From: Elizabeth Lawrence [REDACTED]
Sent: 26 April 2021 12:38
To: Finlay Gardner <Finlay.Gardner@arun.gov.uk>
Cc: Jim Ayling [REDACTED]
Subject: Y/29/21/HH Proposed garage, magnolias, Chuch Lane, Yapton

Application No: Y/29/21/HH
Site Address: Magnolia Church Lane Yapton BN18 0ER
Description of works: Erection of double garage.

project			
MAGNOLIAS CHURCH LANE YAPTON ARUNDEL BN18 0EH			
drawing title			
PROPOSED GARAGE BLOCK PLAN			
date			
11/01/2021	scale	1:500 @ A1	
job no.	drg. no.	rev	
JA-MAG-02	01	A

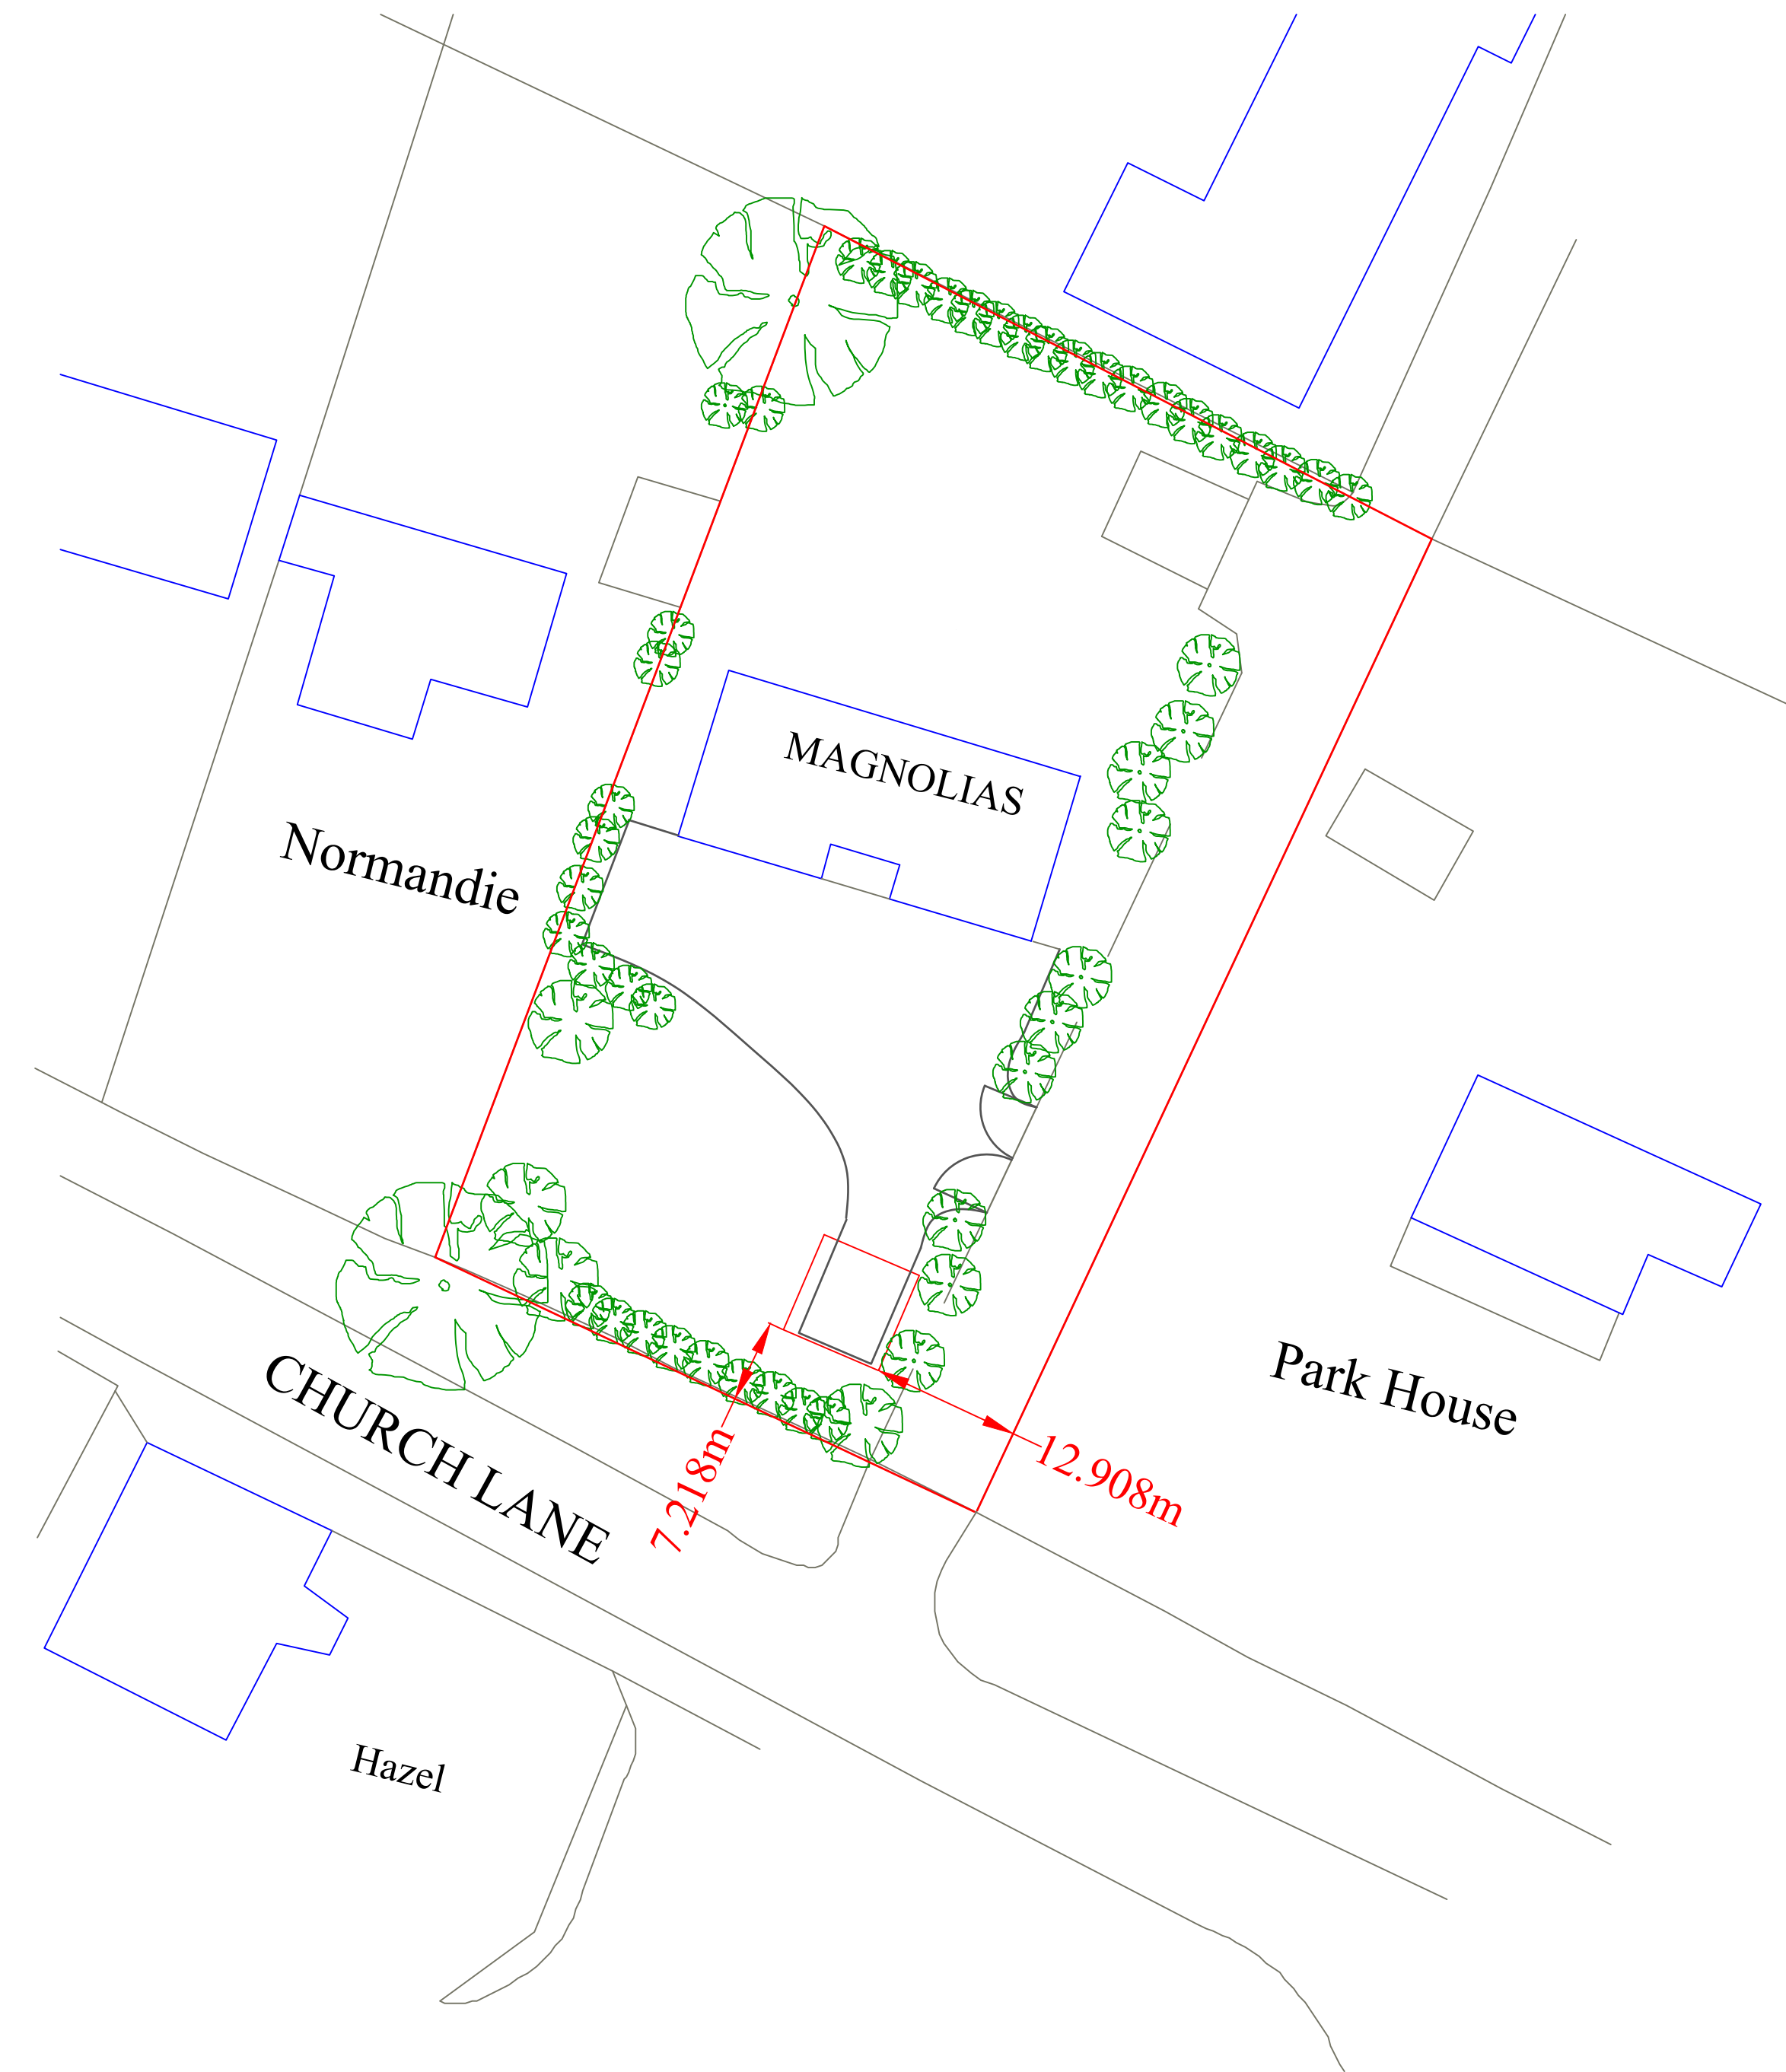
- YPC note that the proposed unit encroaches a clearly set and established building line that runs along the northern side of Church Lane. YPC is strongly against this building line being broken as it maintains the integrity of the overall Church Lane street scene and setting to the adjacent conservation area.
- The height of the unit is also out of keeping with Church Lane. The overall impact of the height is further compounded by the nature of the levels of the land along the northern stretch of Church Lane which is significantly raised compared to the southern side. YPC would expect a single storey unit only.
- YPC note that previous planning history objected to a garage located in this location as over development for the plot. YPC note that there has not been any significant material changes to the plot to counter these grounds of concern/objection.

In 2009 planning permission was granted for a garage and gymnasium to the rear of Magnolias. The construction costs were going to be higher than expected due to the ground conditions and so the applicant decided to move the position of the building to the front garden where ground conditions were better (In a similar but more open position to the proposed). The case officer raised no objections. The Parish misunderstood what was proposed and thought the applicant wanted 2No. two storey buildings and 2 gymnasiums. They considered that this would amount to the over-development of the site and objected solely on this basis. They did not object to the revised position of the building (I attach a copy of their written objection).

As it happens the applicant decided to materially reduce the size of the approved garage for financial reasons and so there was no need to re-site it. Hence they withdrew the application to re-site the approved building.
